Re: Office Development
4700 Eubank Blvd. NE
Traffic Circulation Layout
Architect's Stamp 10-25-22 (F21-D073)

The TCL submittal received 01-04-2023 is approved for Building Permit by Transportation. A copy of the stamped and signed plan will be needed for each of the building permit plans. Please keep the original to be used for certification of the site for final C.O. for Transportation.

January 9, 2023
Project: 4700 Eubank Blvd NE 8300 Palomas Ave NE
Subject: TCL Comment Responses

arcLINE Architectural Design LLC has reviewed and responded to comments generated on 01-06-2023. Please see comment and response below.

AS101a

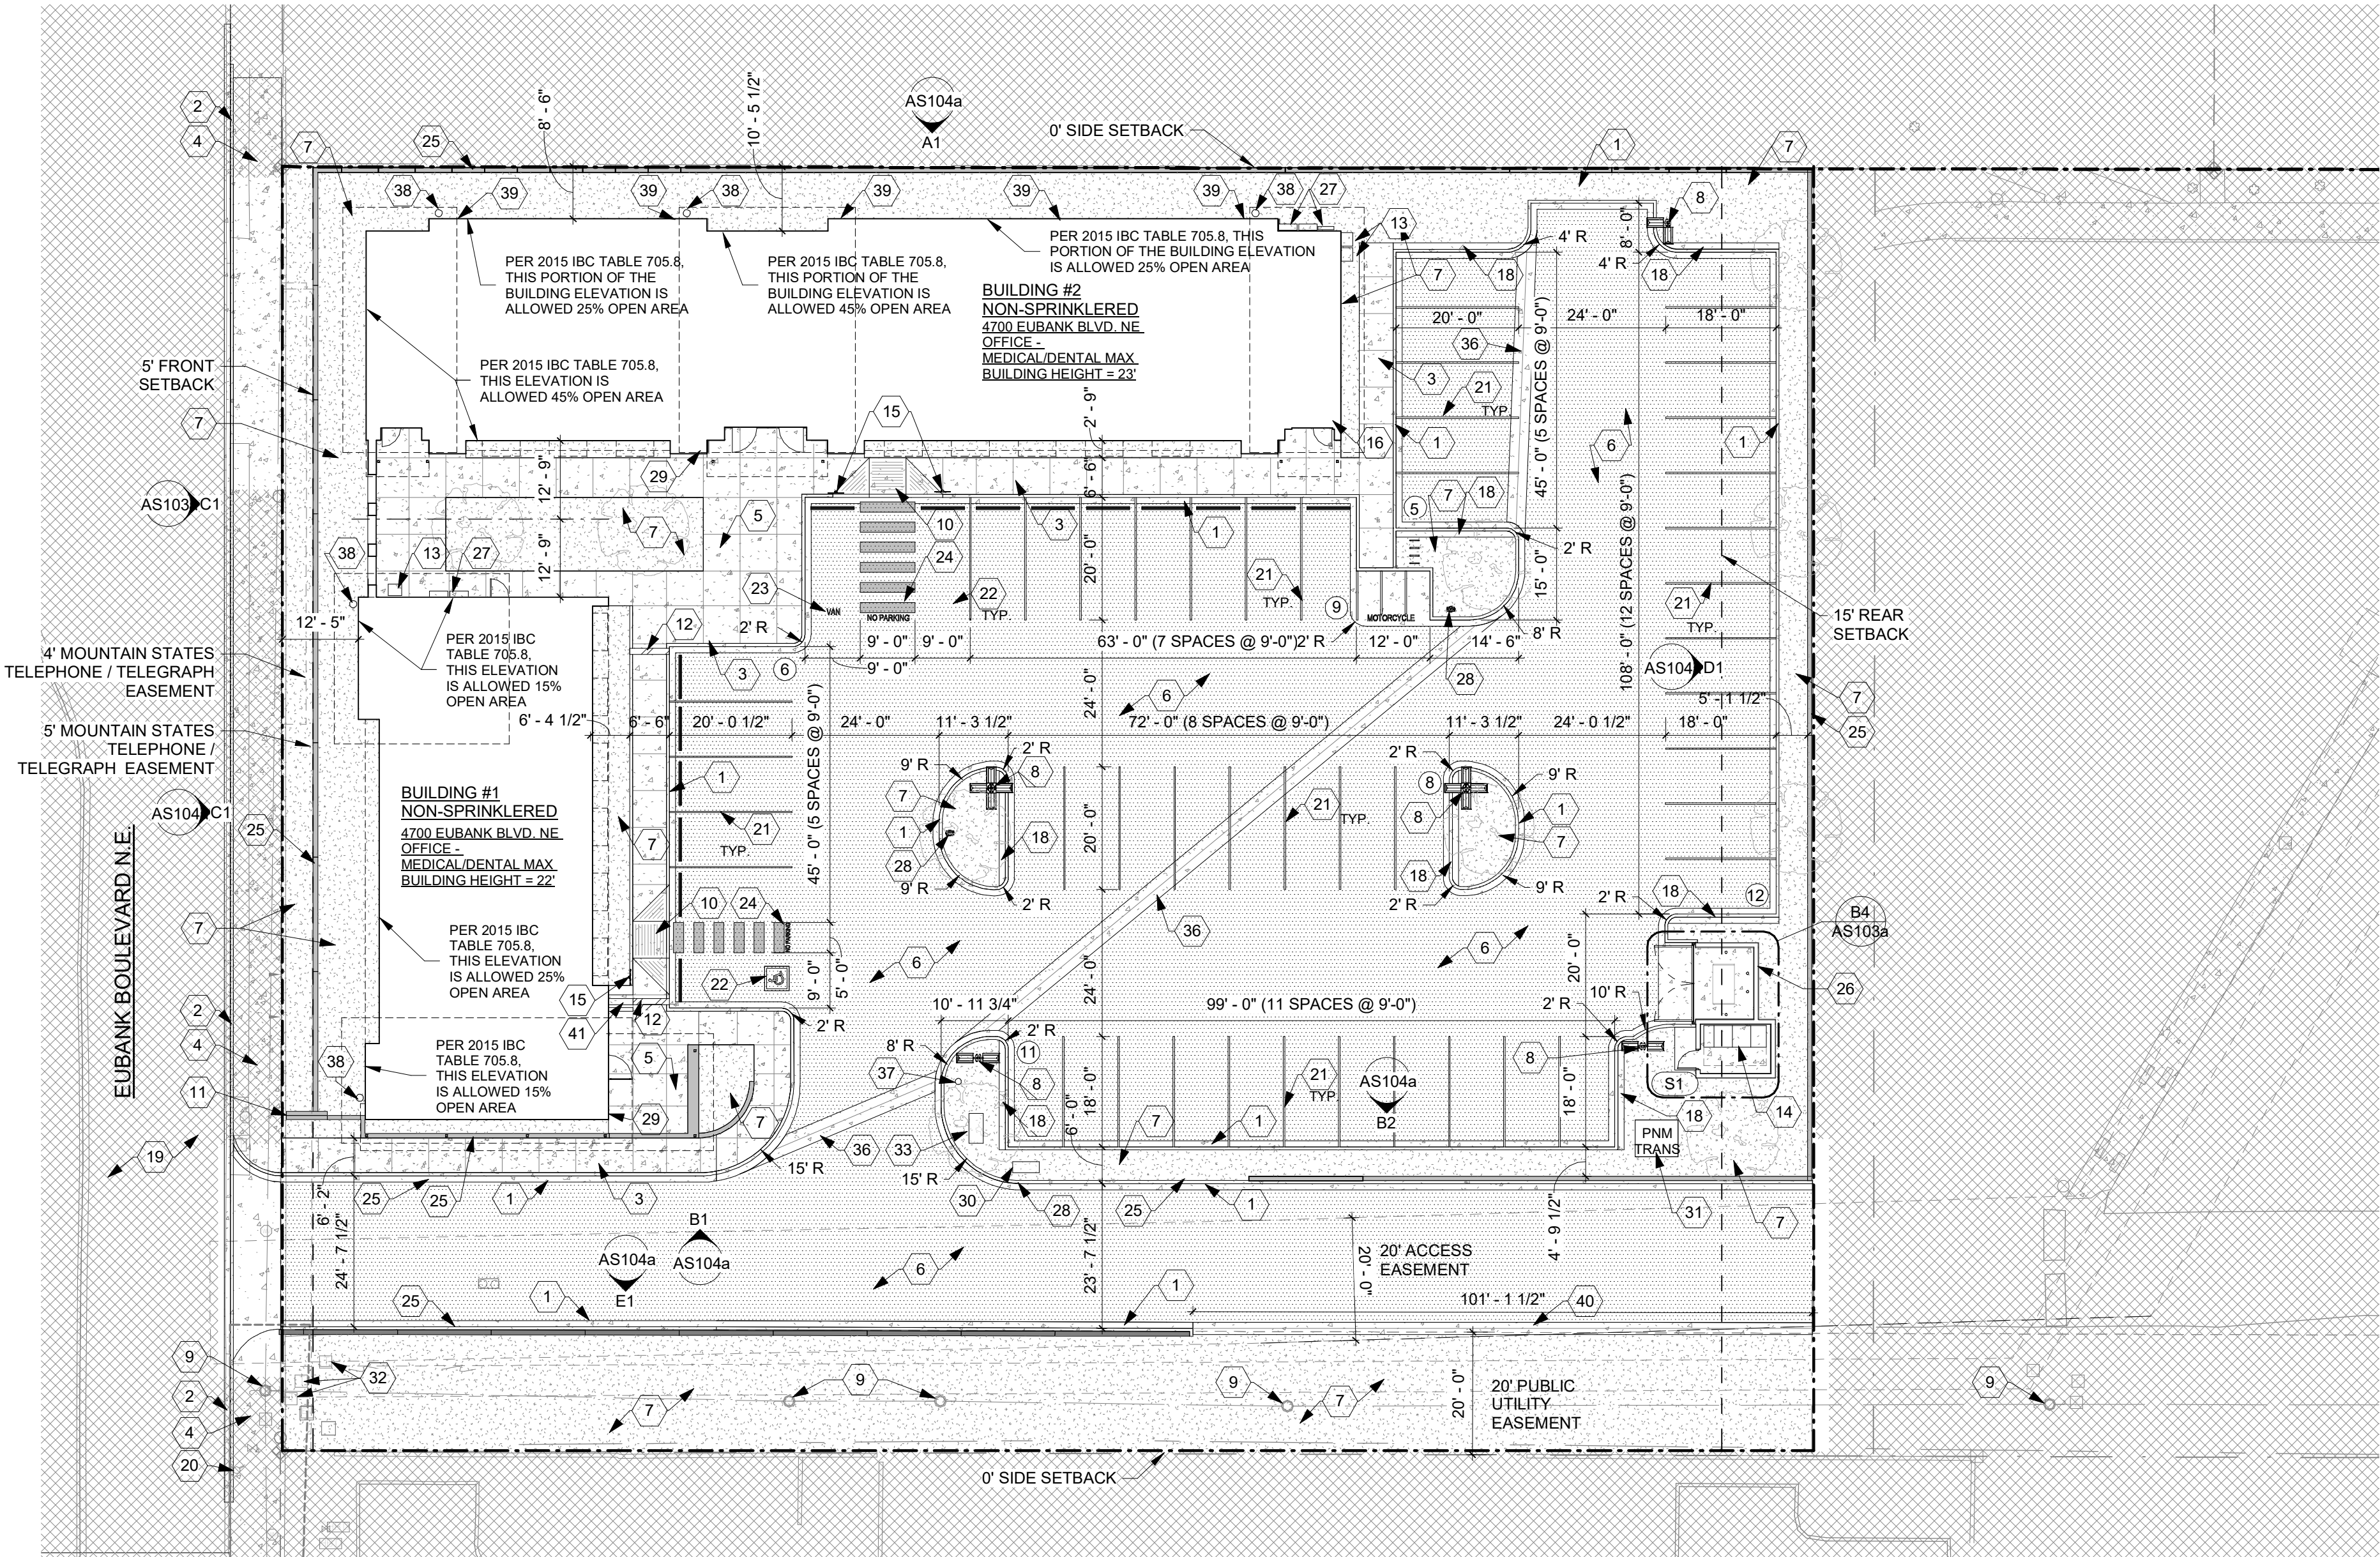
1. Show the clear sight triangle (11' X 11') on the site plan and it should start at the back of the sidewalk. .
 - a. The clear sight triangle has been added to sheet AS101a.
2. Show on the site plan the ADA pavement symbol on the ADA parking spaces at the south side of building 2.
 - a. The ADA pavement symbol is now indicated on the ADA parking spaces for building 2 on sheet AS101a.
3. Keynote 10: it appears the proposed ADA ramps will not be competent in this place. Suggestion, please refer to COA std dwg 2443, detail A- parallel curb ramp. See attached COA std dwg 2443 ADA ramp details.
 - a. The ADA ramps for building 1 and building 2 has been changed on sheet AS101a to reflect COA standard drawing 2443.
 - b. The ADA ramp detail on sheet AS102a has been changed to
